Application No: K/2/22/HH
Site Address: 43 Golden Avenue East Preston BN16 1QX
Description of works: 2 storey front and rear extensions and alterations.

Thank you for your internet representation made on 23rd February 2022 which has been recorded as an objection with the comments as follows:

West Kingston Residents Association would like to object to the proposed development for the following reasons.

Proposed Second Floor Plan

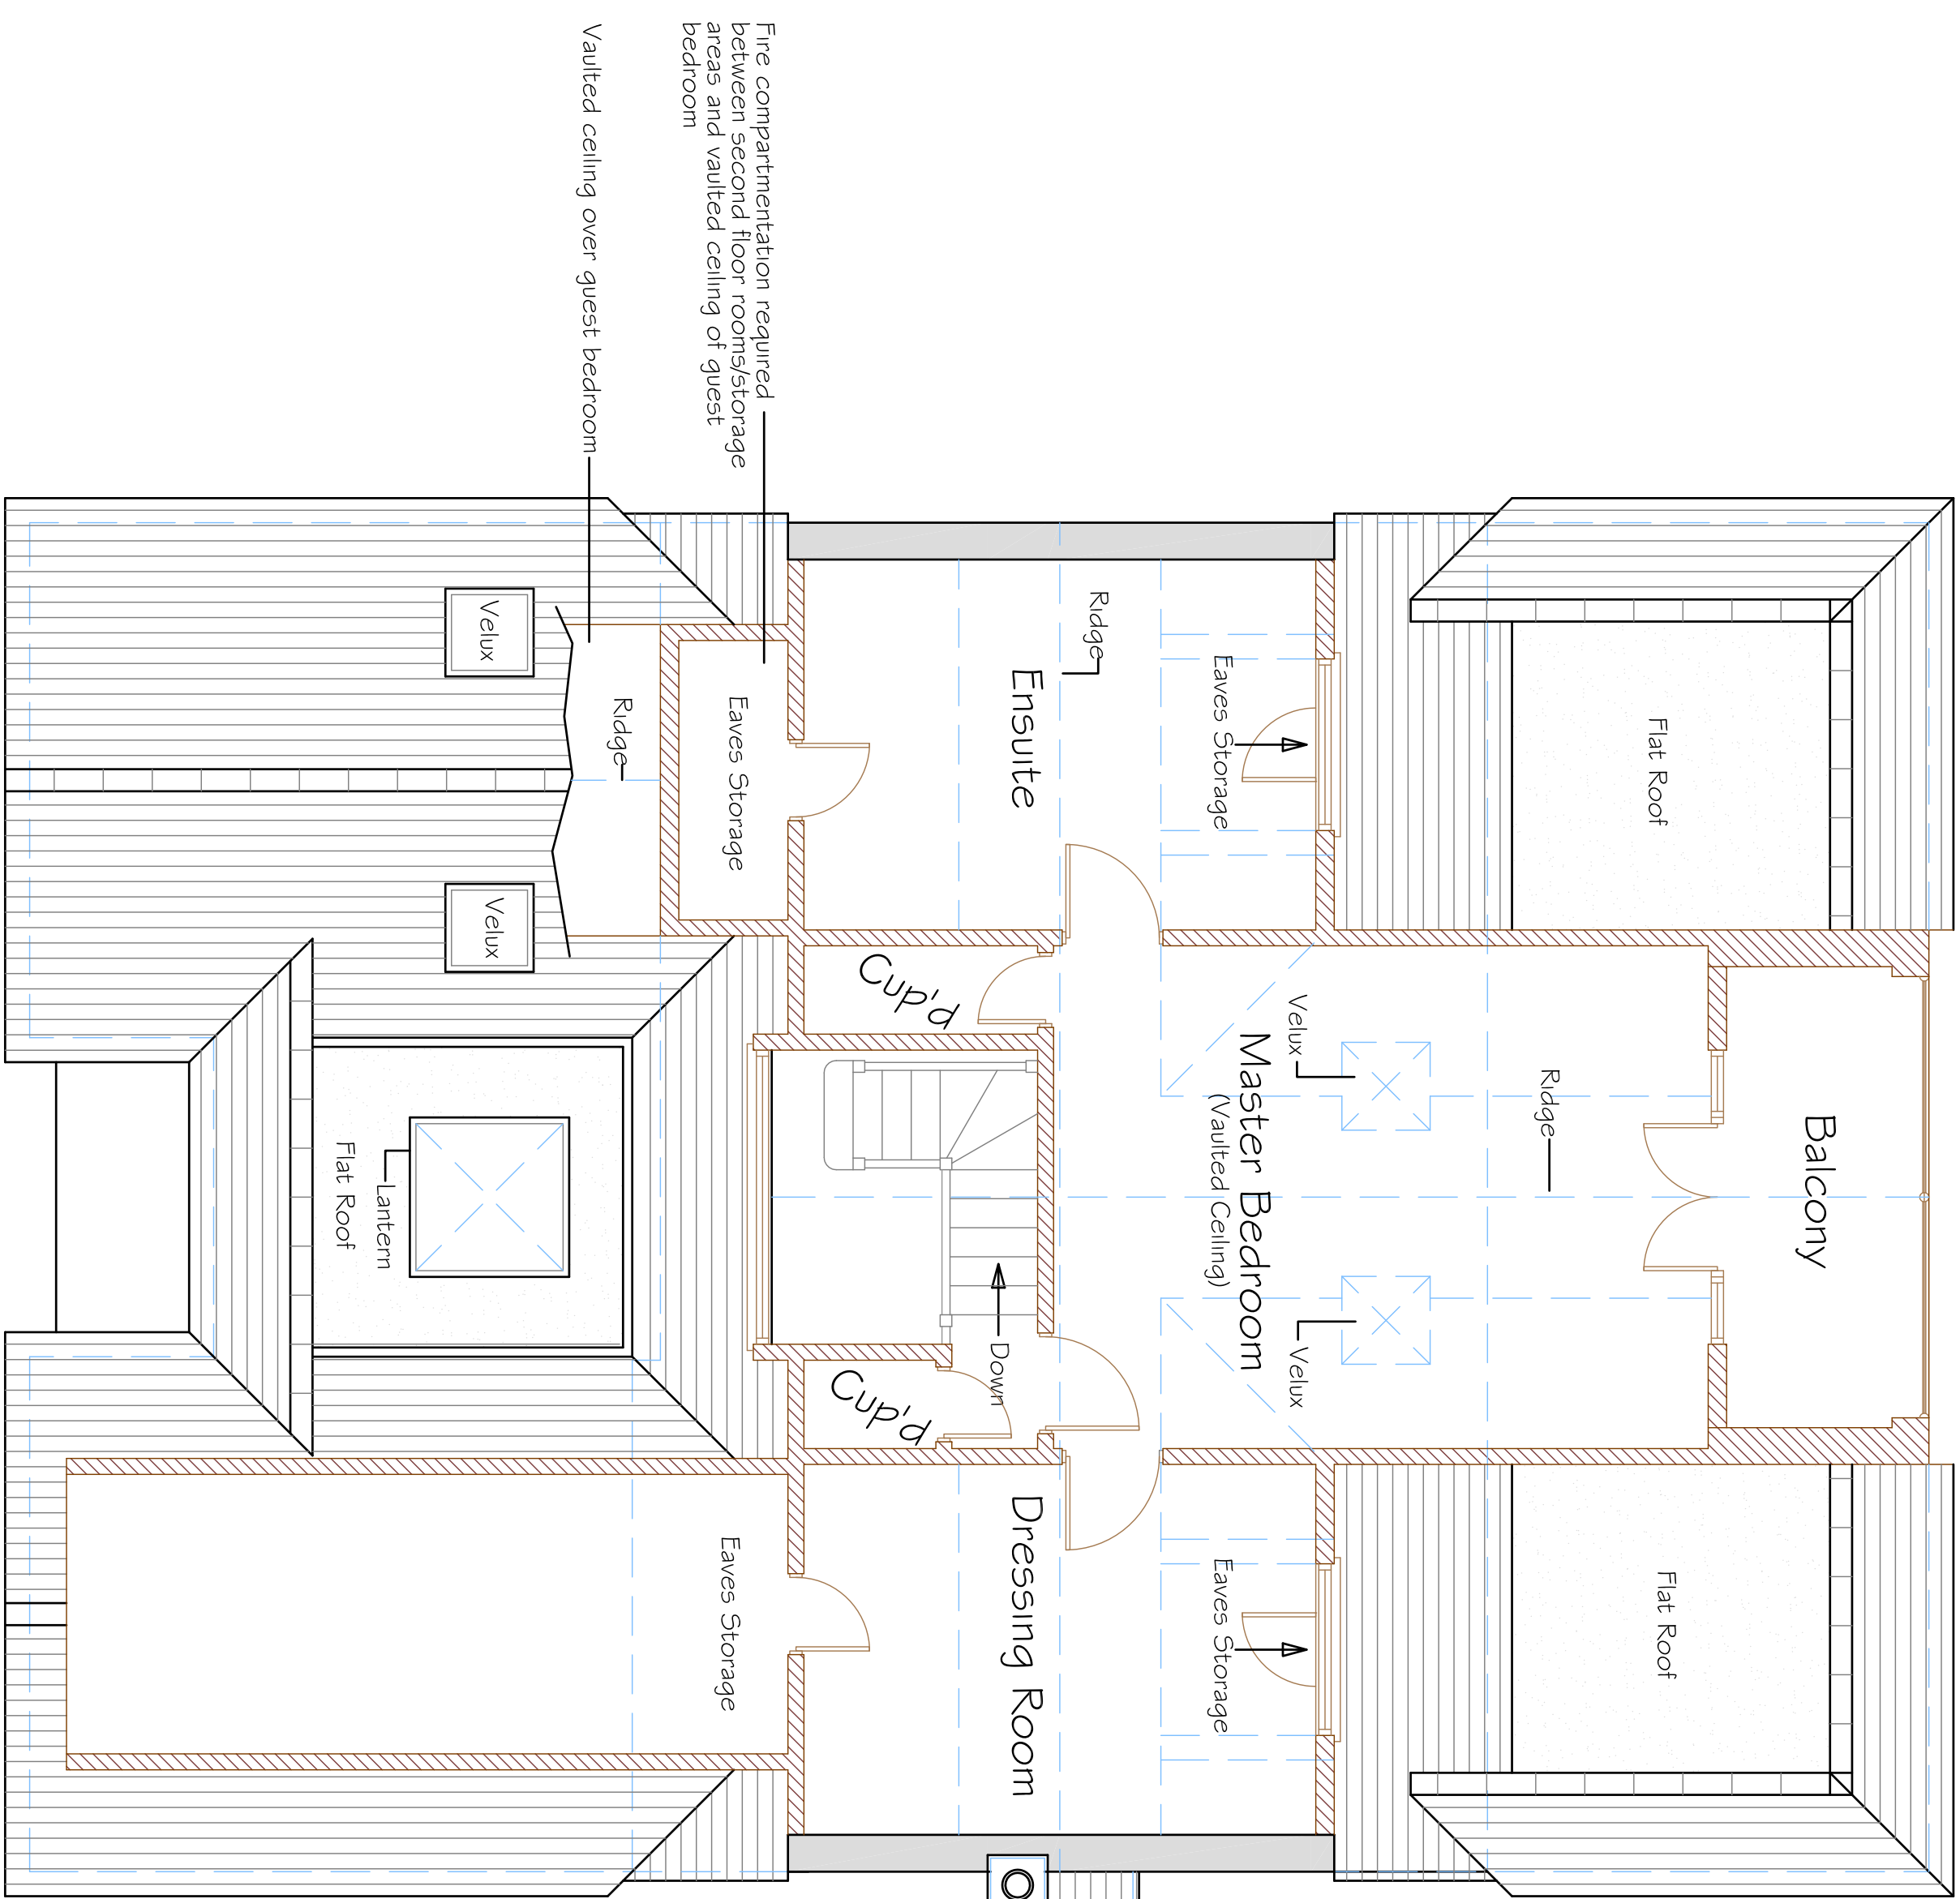
3. Privacy. Neighbouring properties will be overlooked with the addition of a substantial third storey to the rear.

Drawing: STREET SCENE/PARKING

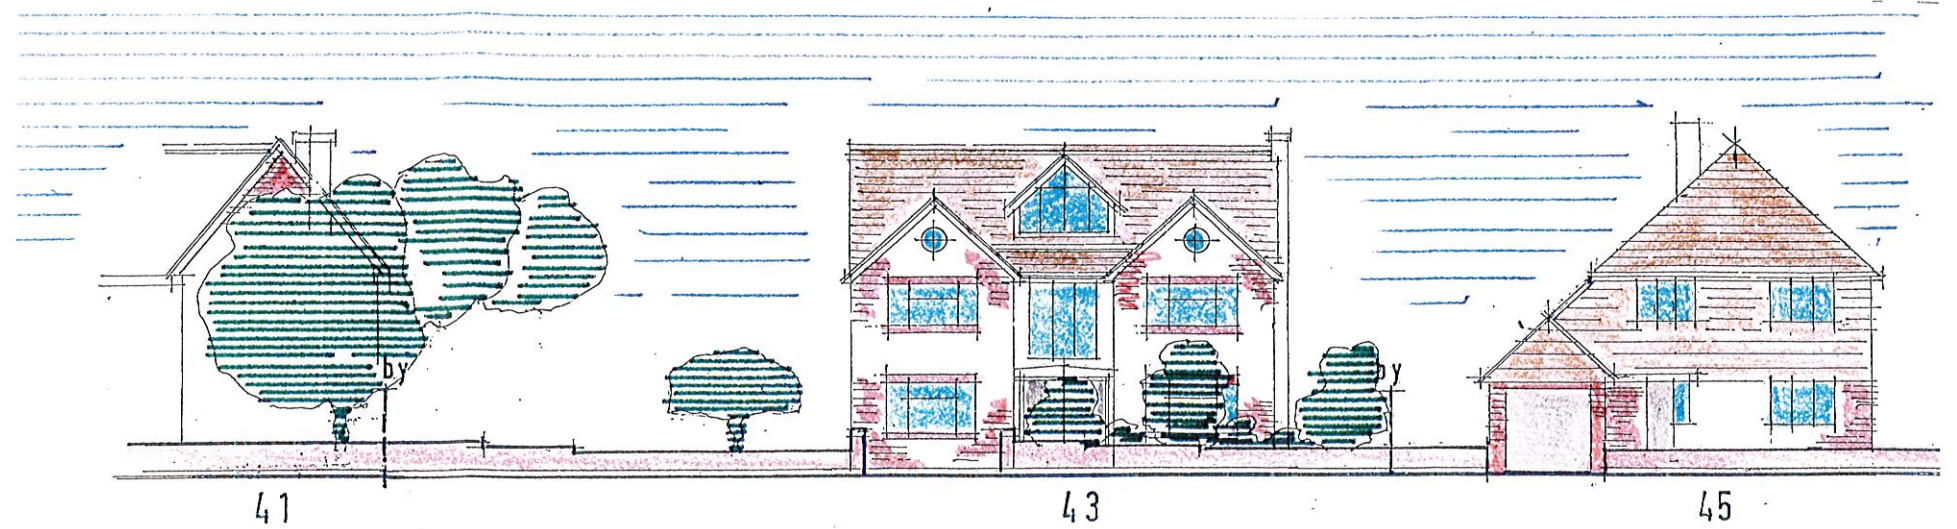
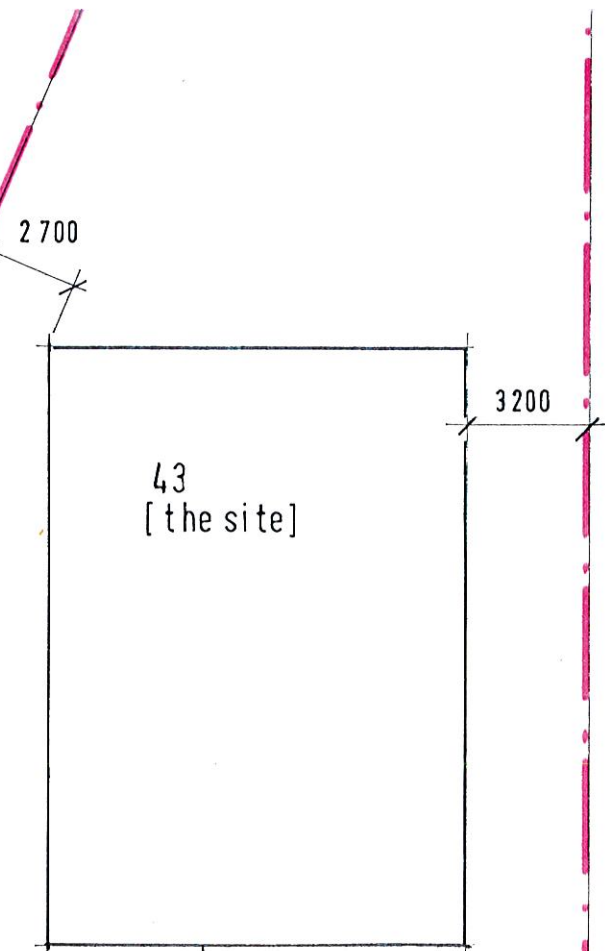
2. The current plans have no provision for parking. The property has plans for 6 bedrooms and only a limited amount of potential space for parking at the front. A property of this size will naturally generate a large number of vehicles regardless of its final usage. The property is situated on a blind corner with a double white line. Estate rules stipulate that parking on the road is prohibited in this area as it can prove to be a hazard to pedestrians and road users alike as a result of the road layout.
